## **Boston Alternative Energy Facility**

Worst Case Assessment for Land Raising (Tracked)

Document Reference: 9.77 (1)

**Subject:** ~~Boston Alternative Energy Facility: Deadline 7 – Worst Case Assessment for Land Raising~~  
Boston Alternative Energy Facility: Deadline 9 - Worst Case Assessment for Land Raising

TITLE
WHARF GENERAL LAYOUT
DRAWING
FIGURE 5.2 - SHEET 1 OF 3

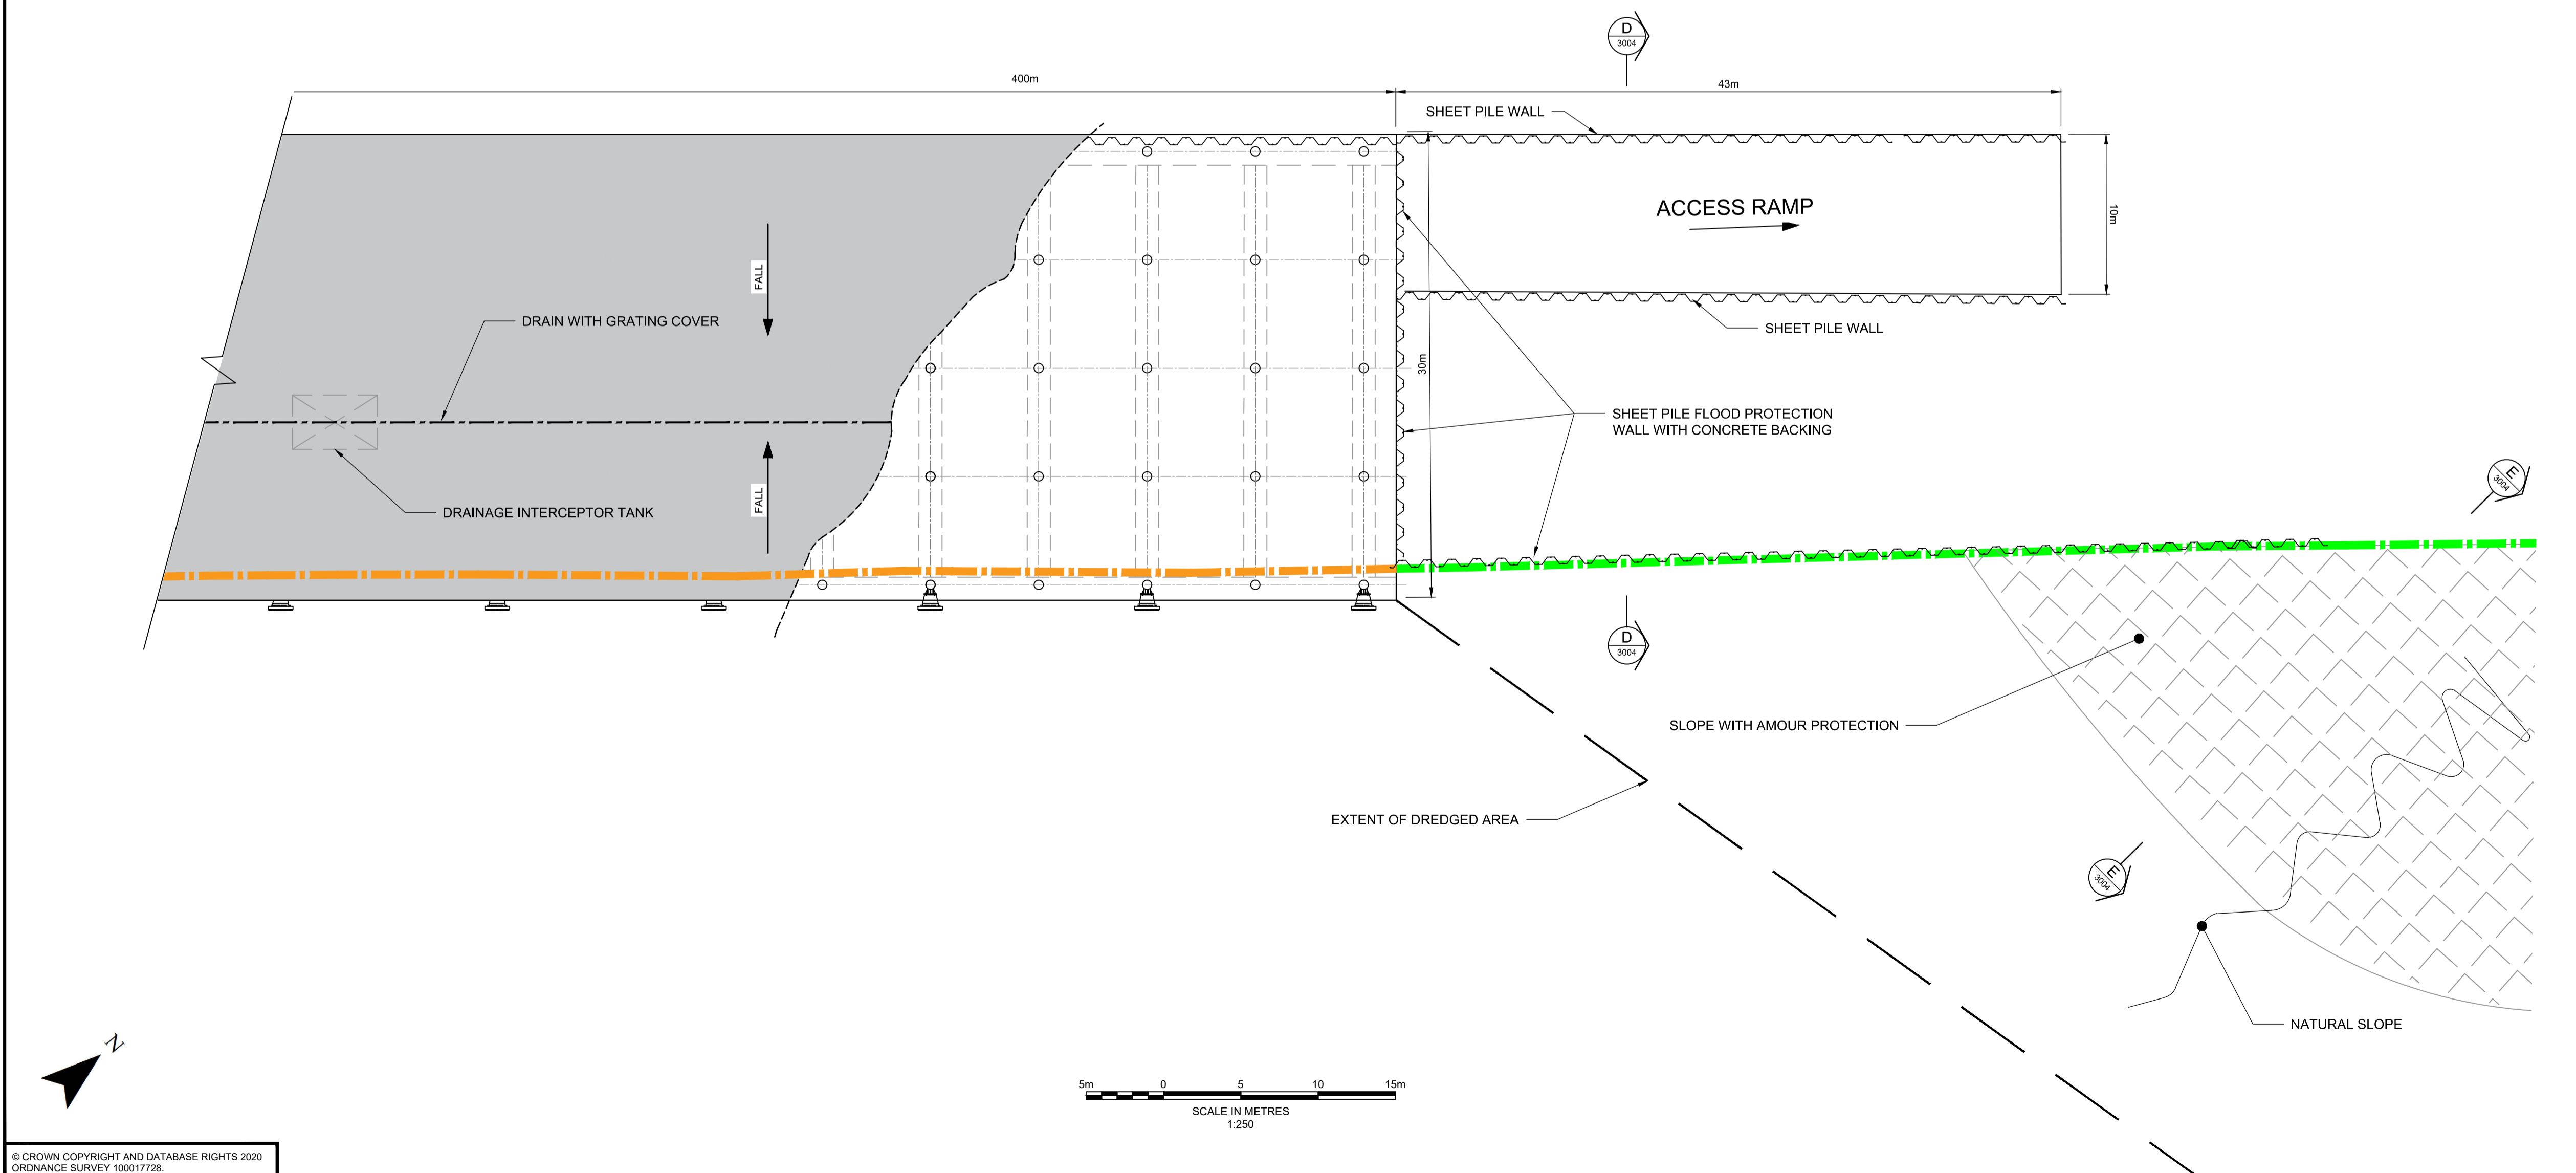
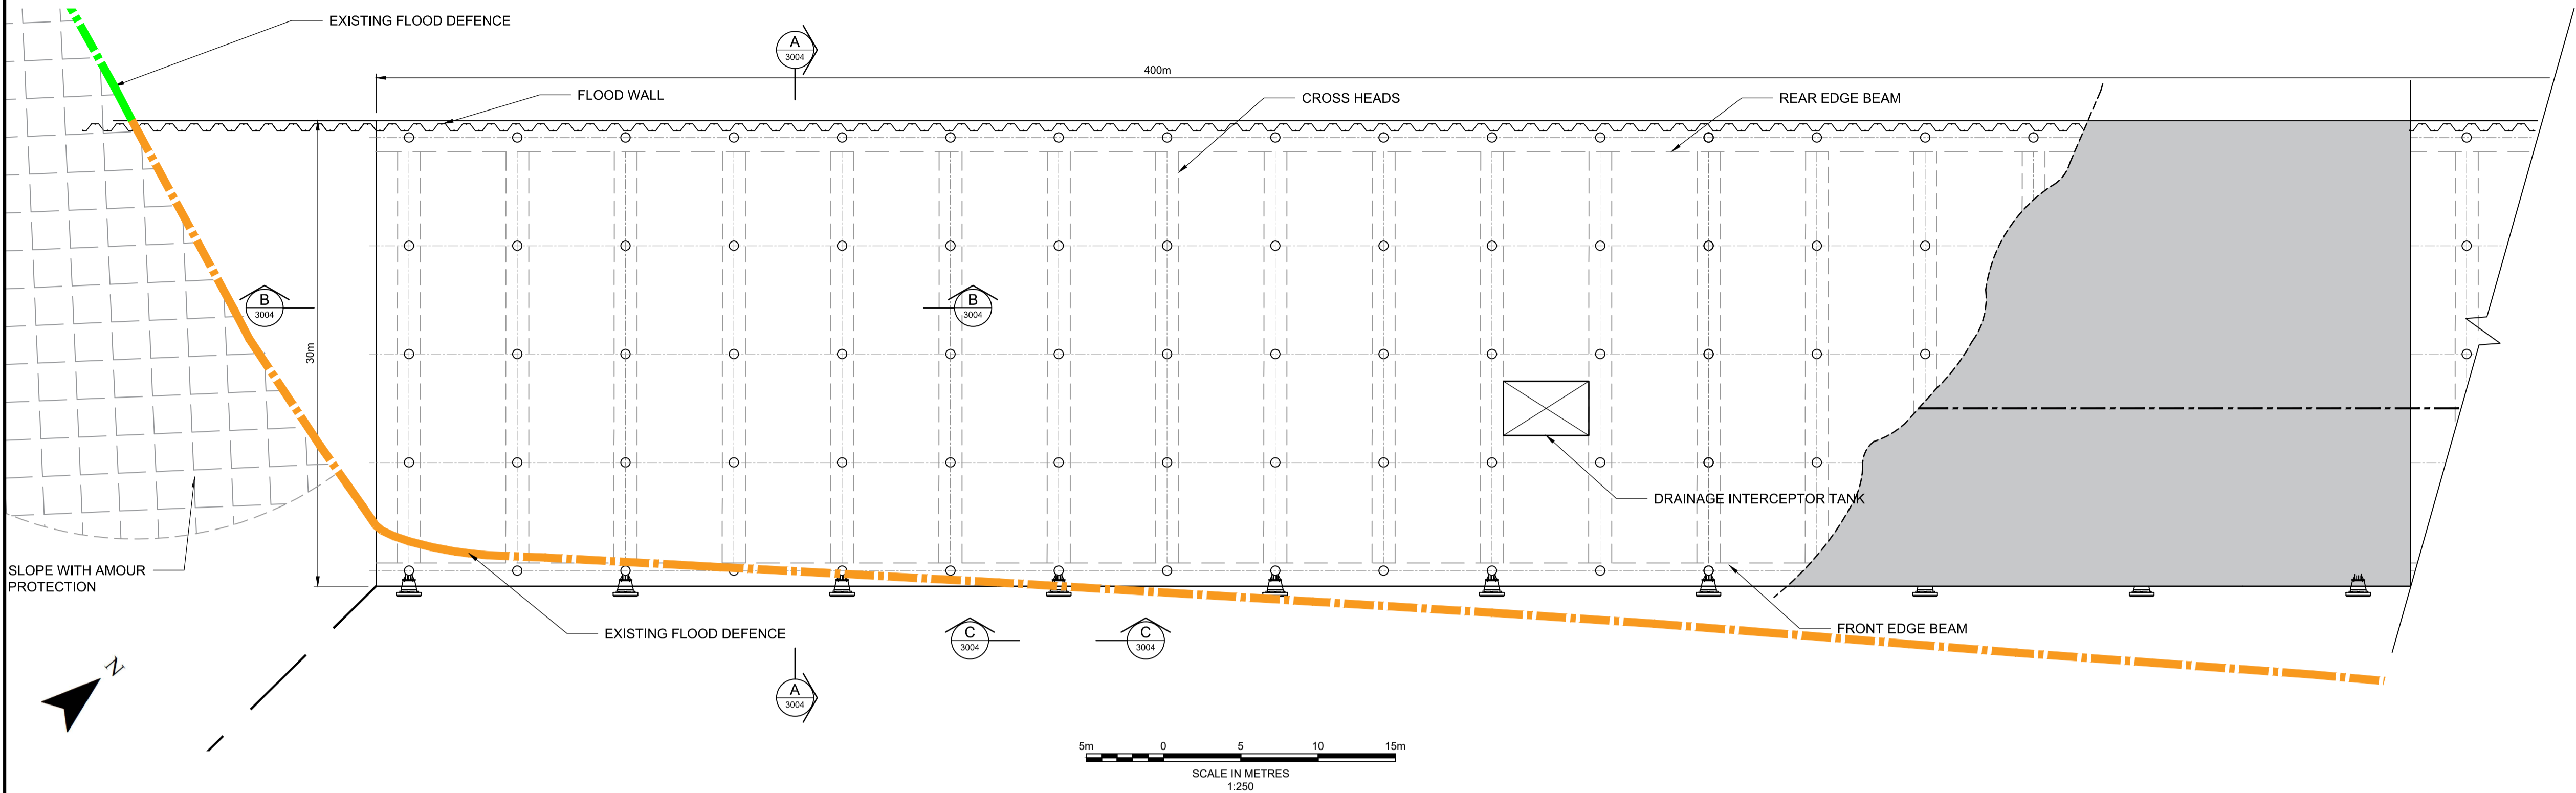
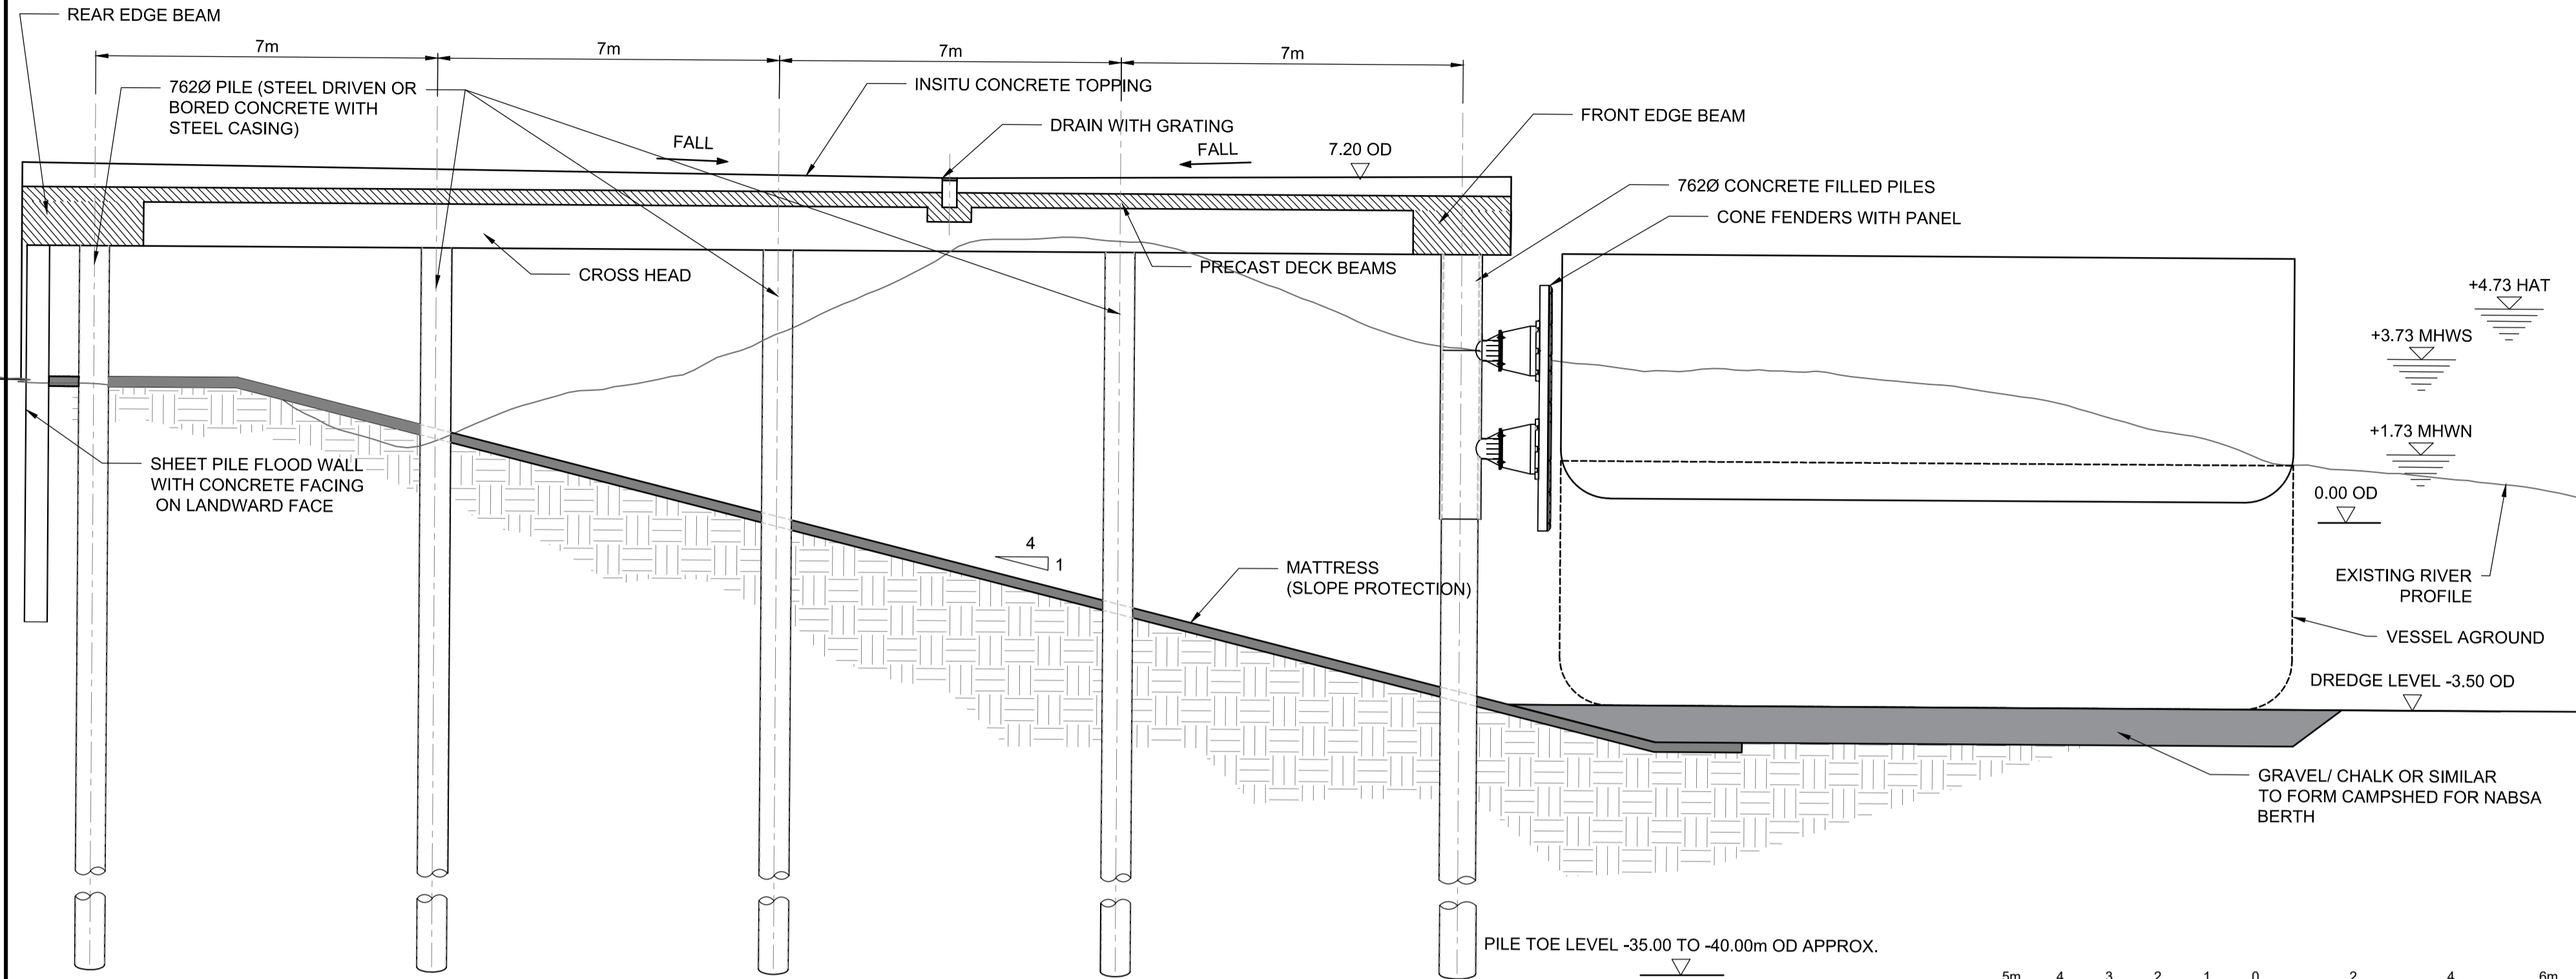
*2.4. We have reviewed document ref REP7-009 (Worst Case Assessment for Land Raising). We consider the document is a reasonable assessment of the possible impacts on flood flows as a result of land raising and has addressed some of our concerns. However, the assessment does not include an assessment of works taking place in the area between the proposed wharf and Roman Bank. The assessment must be updated to see what impact (if any) may arise as a result of works in this area.”*

4.1.3 Furthermore, it is noted that, in their Deadline 8 submission (REP8-019), the Environment Agency requested the same assessment be undertaken for the land between the proposed wharf and the Roman Bank. However, the Applicant notes that this part of the site has also been omitted from the assessment on the basis that the land in this location will not be subject to the same cut and fill exercise as the Principal Application Site.

4.1.4 Whilst it is acknowledged that the undeveloped site, comprising mainly agricultural land, may have some minor localised variations in topography (noting it is currently a relatively flat site) there is no proposal for a comprehensive cut and fill exercise to adjust the level of the land either up or down between the proposed wharf and the Roman Bank.

4.1.5 In addition, the proposed wharf is to be located to the riverward side and in line with the footprint of the existing defence extending inland only as far as the rear of the existing embankment. After this point there will be a drop in the level from the proposed wharf to the development behind so that it matches the existing ground levels to the rear of the existing defence.

4.1.24.1.6 It is on the basis of the above that the land between the proposed wharf and Roman Bank has been omitted from the assessment as no change in ground levels means there will be no reduction in flood storage in this location post-development compared with the existing scenario.
